Recommendation Report for Planning Permission for Works or Extension to a Dwelling

REF NO: BR/233/21/HH

LOCATION: 77 Hillsboro Road
Bognor Regis
PO21 2DY

PROPOSAL: Hip to gable loft conversion with 2 x side dormers

PROPOSED ELEVATIONS

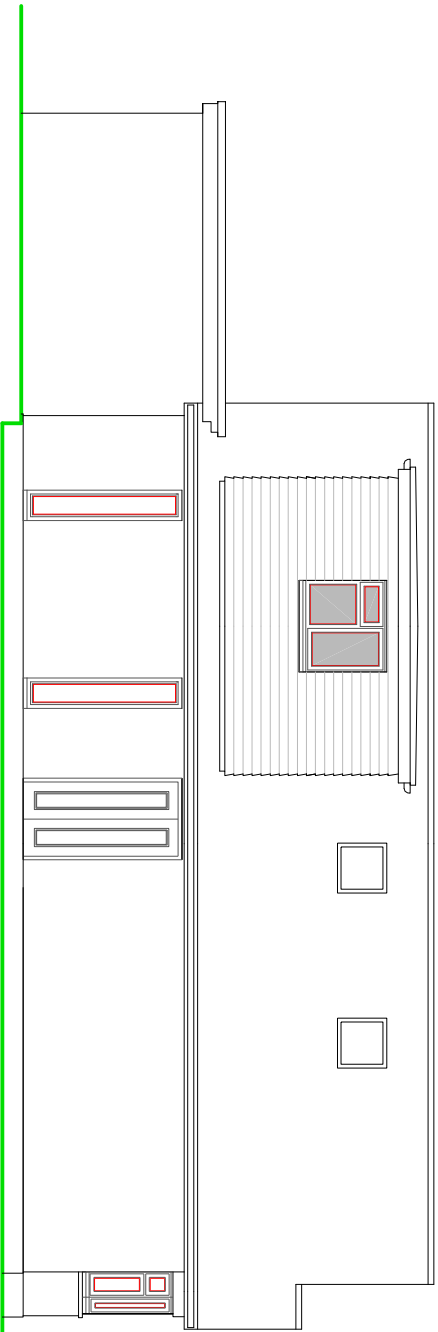
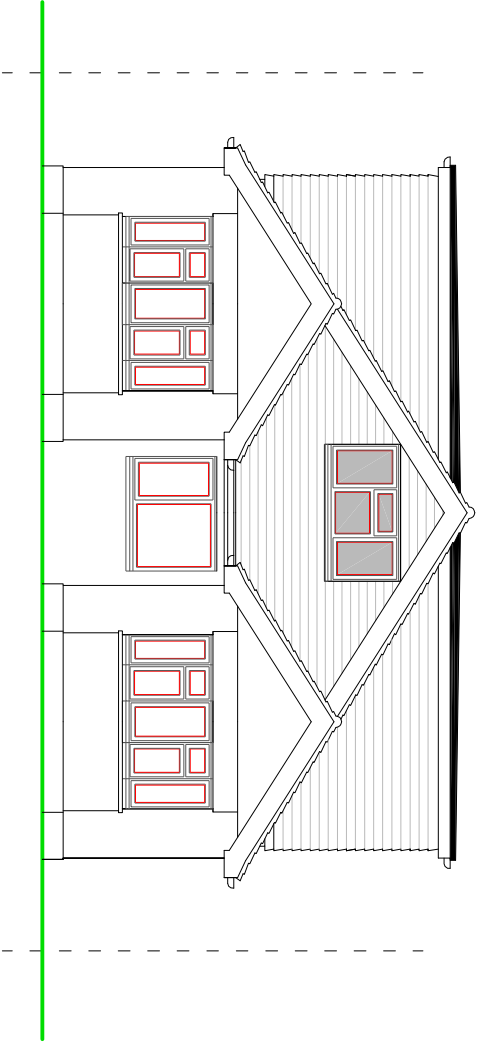
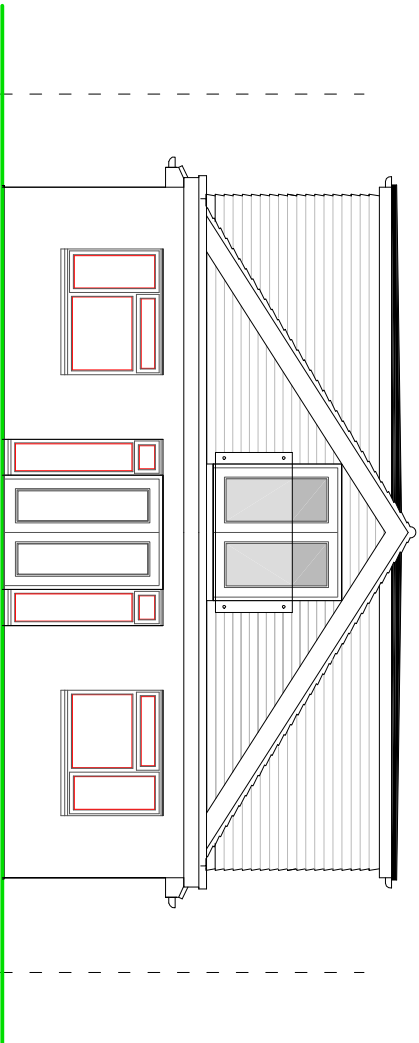
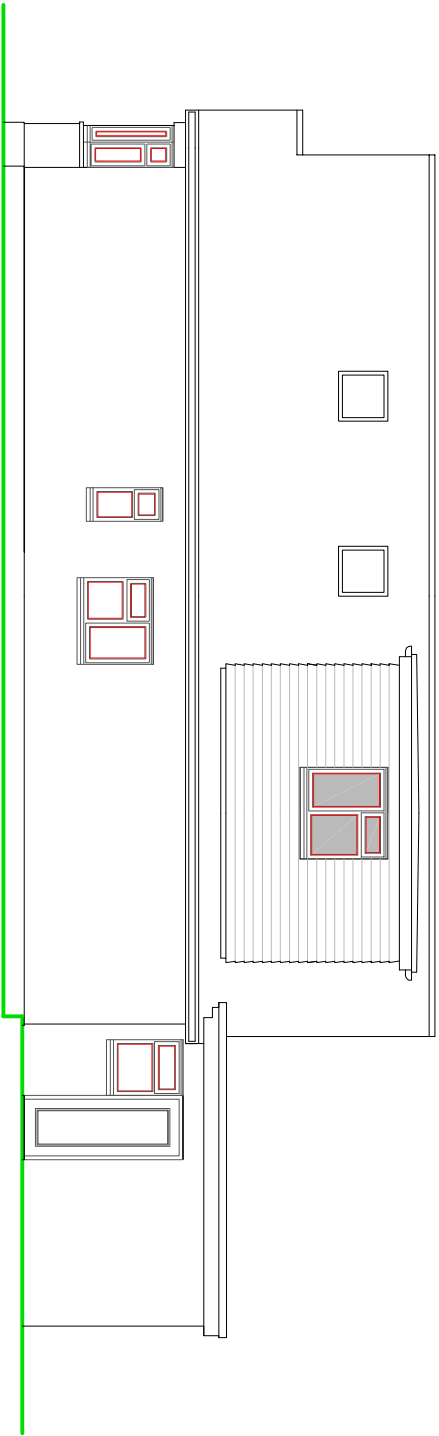
The proposals are for a hip to gable loft conversion with 2 x side dormers. Due to the siting to front sides the hip to gable loft conversion will be highly visible from street scene and adds bulk to existing roof line and therefore do not appear subservient to the host dwelling and so in this regard conflict with policy D DM4 of the Arun Local Plan. However they are not considered out of character due to there being a mixture of designs within street so does not adversely impact street scene or surrounding character of area so complies with policy D DM1 of the Arun Local Plan.

The proposal will have the same height as existing roof ridge. The gable ends will extend in length to the front at first floor however it retains around 4.55m to the front boundary and is in line with existing building line to front so is acceptable.

The two side dormers will be sited to the north east and south west roof planes. Due to siting to sides they will be highly visible from the street scene. They are a large addition to the sides of the property due to their box shaped design. However they could be done under Permitted Development dependent on the size and materials used so are acceptable.

The dormers will be approximately 4.23m wide x 2.63m high x 4.16m deep. They will both contain one new large window (2 panes) each.

There will also be installation of two new roof windows to both north east and south west roof planes at first floor. These are sited towards the centre / front of the roof so will be visible from street scene but will not cause adverse impact due to being set back from street scene by around 6.87m.

It also states that small scale dormer windows with pitched roofs are favoured over large, flat box-shaped designs. Whilst the proposal doesn't comply it is below the roof ridge line and they could be done under Permitted Development dependent on the size and materials used so is acceptable.

It also states that when extensions include roof lights, these should maintain the privacy of neighbouring properties. It states any roof light located on the roof slope of a side elevation should use obscured glass. A condition will be required to obscure glaze the new roof windows to be installed on the north east and south west side roof slopes.

The proposed materials seem to match existing property and consist of plain clay tiles to pitched roof to match, GRP covering to new dormers, plain tile hanging to walls, and white framed UPVC windows and doors so complies with D DM1 and D DM4 of the Arun Local Plan.

Due to the two new dormer containing two new windows to the north east and south west there is increased risk to overlooking to neighbouring property no. 79 to north east and no. 75 to south west however the new dormer windows will be obscured glazed and non opening below 1.7m from floor level as per the plans submitted so is acceptable.

Due to two new roof windows to north east roof plane there is increased risk of overlooking to no. 79 roof windows to north east first floor. A condition will be required to obscure glaze the roof windows and be non-opening unless the parts of the window which can be opened are more than 1.7 metres above the floor of the room in which the window is installed to protect neighbouring amenity.

Due to two new roof windows to south west roof plane there is increased risk to overlooking to no. 75 to south west first floor however due to a gap of around 4.49m to neighbouring property. A condition will be required to obscure glaze the roof windows and be non-opening unless the parts of the window which can be opened are more than 1.7 metres above the floor of the room in which the window is installed to protect neighbouring amenity.

- 3 The roof windows on the north east and south west elevation of the building shall at all times/be glazed with obscured glass/fixed to be permanently non-opening unless the parts of the window which can be opened are more than 1.7 metres above the floor of the room in which the window is installed.

PROPOSED FIRST FLOOR PLAN

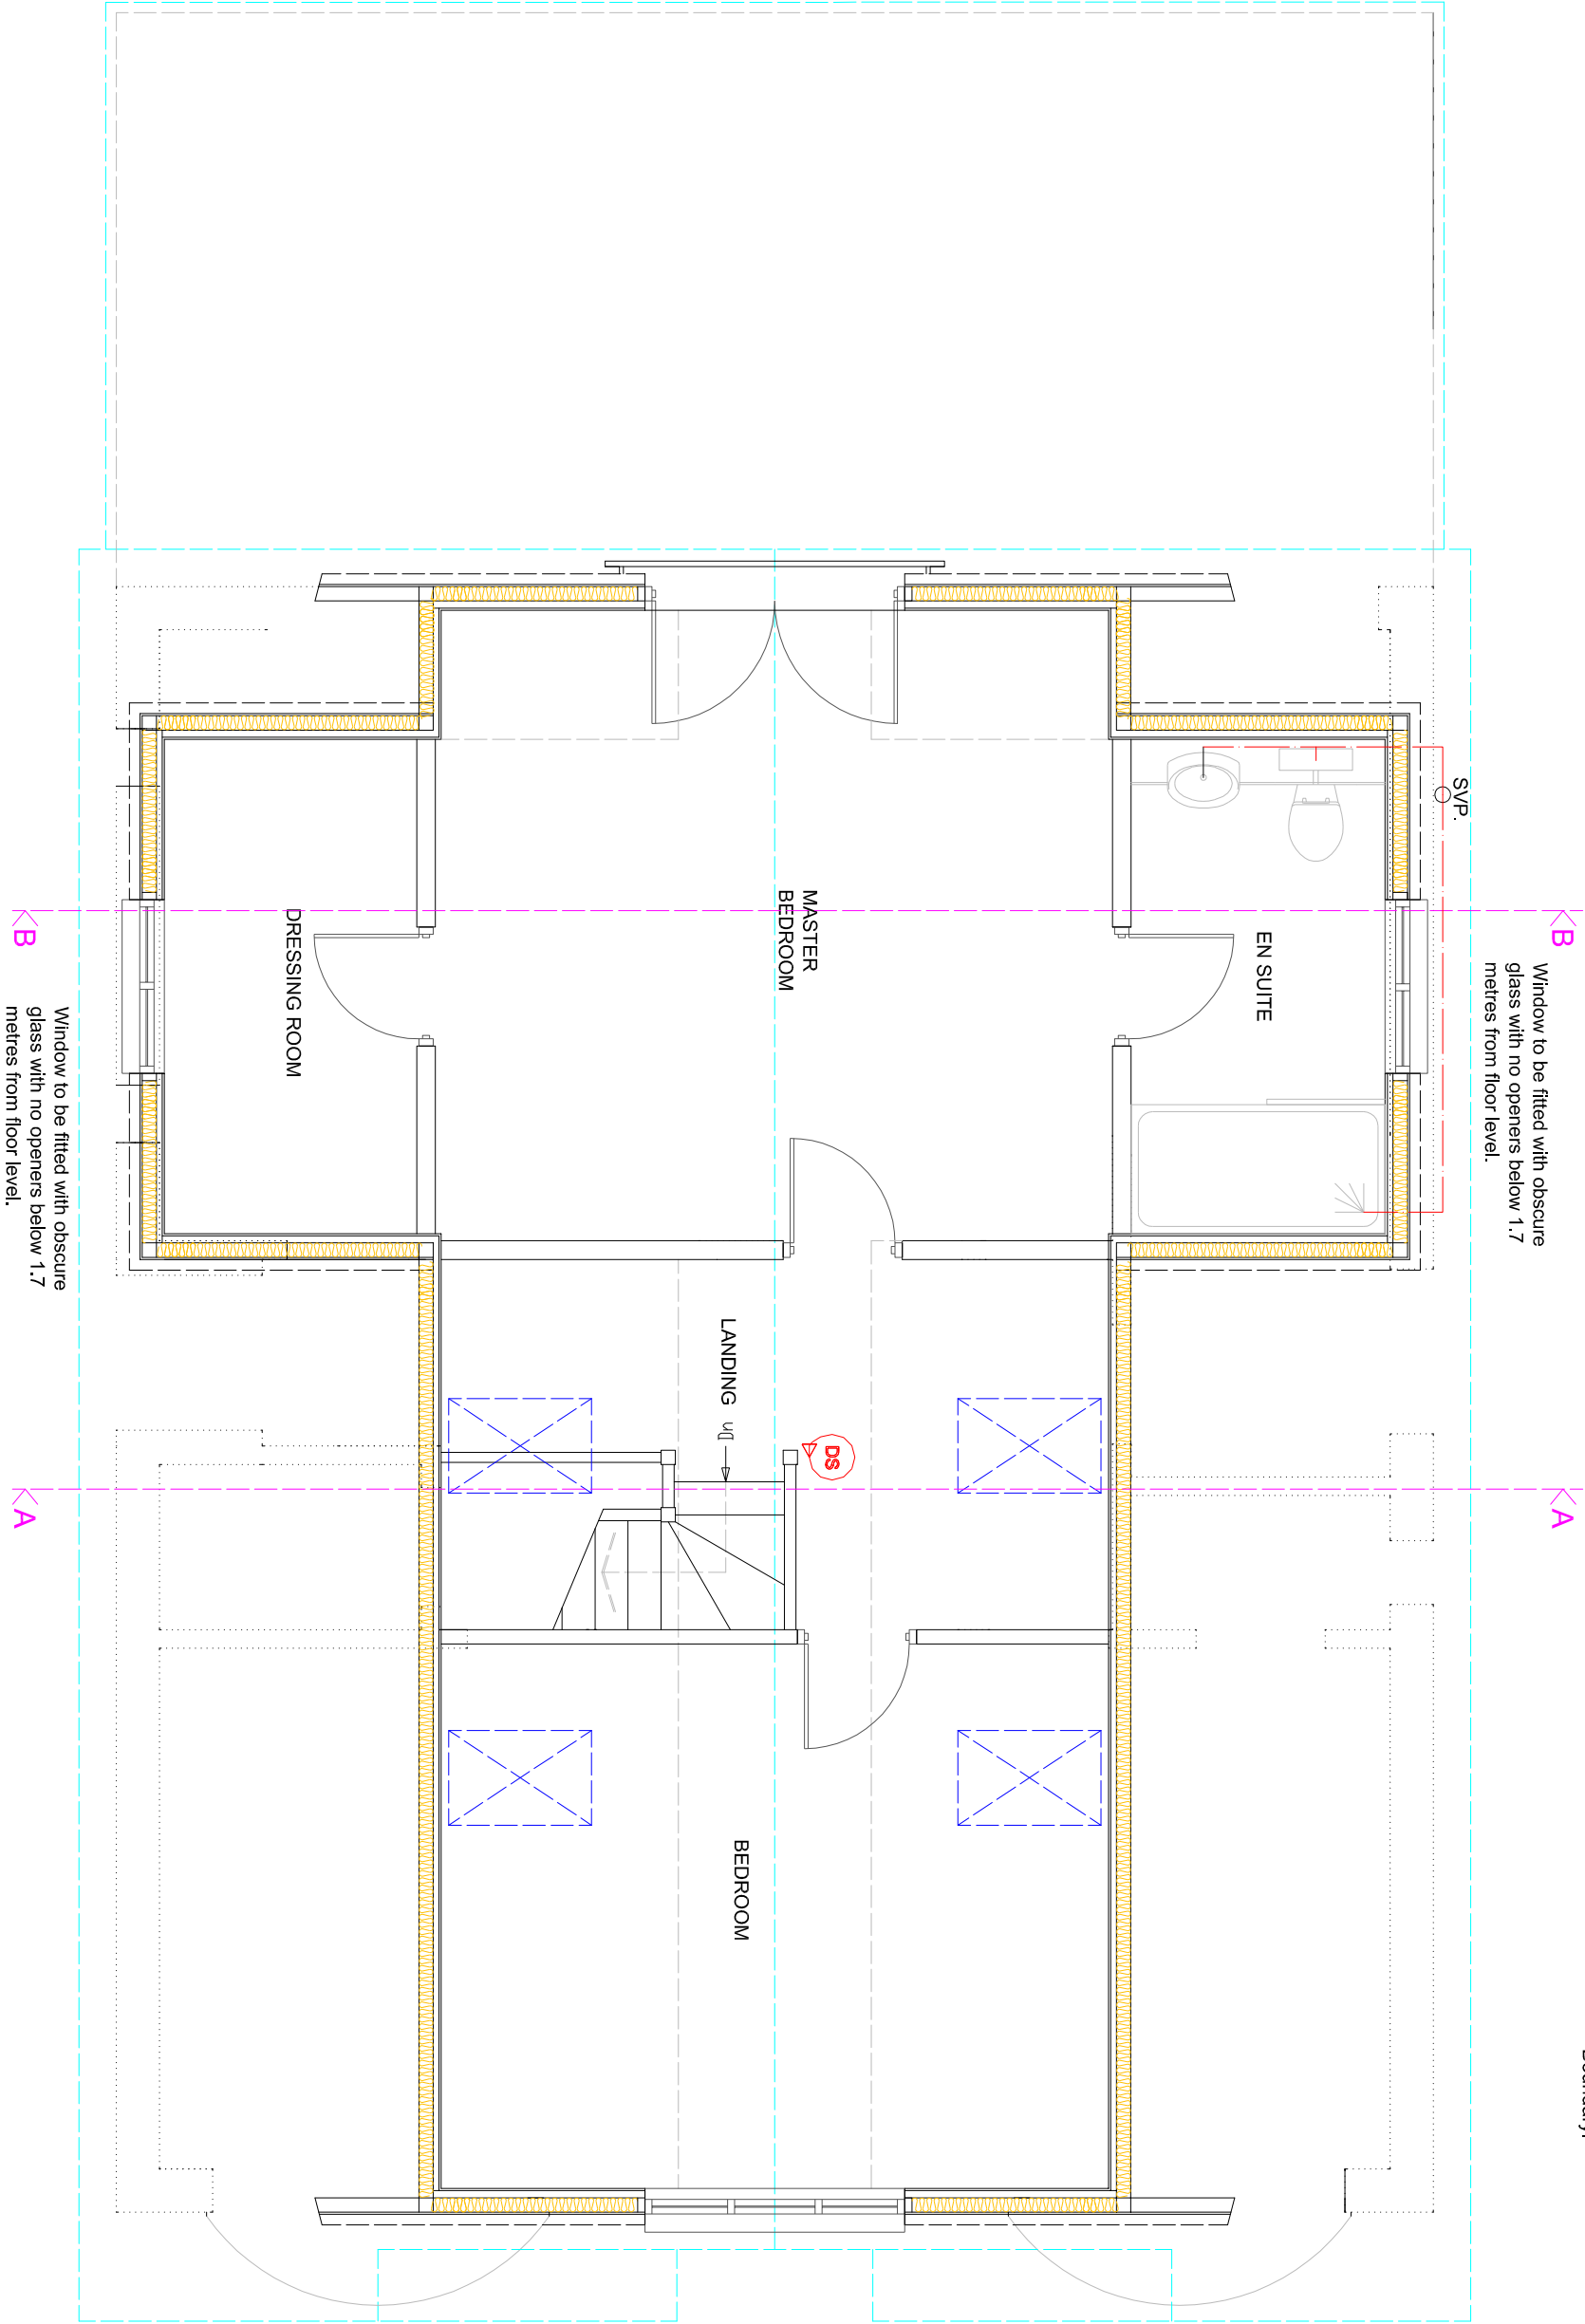
To the rear the proposal retains a gap of around 3.95m to the rear (south east) elevation of property. There is a gap of approximately 1.3m retained to both north east and south west side boundaries. There is 26.1m retained to the rear (south east) boundary.

The hip to gable loft conversion will form two new bedrooms, a dressing room and bathroom at first floor. It will contain one new window (2 window panes) to front (north west) and one new set of French doors with glass balustrade to rear (south east) at first floor.
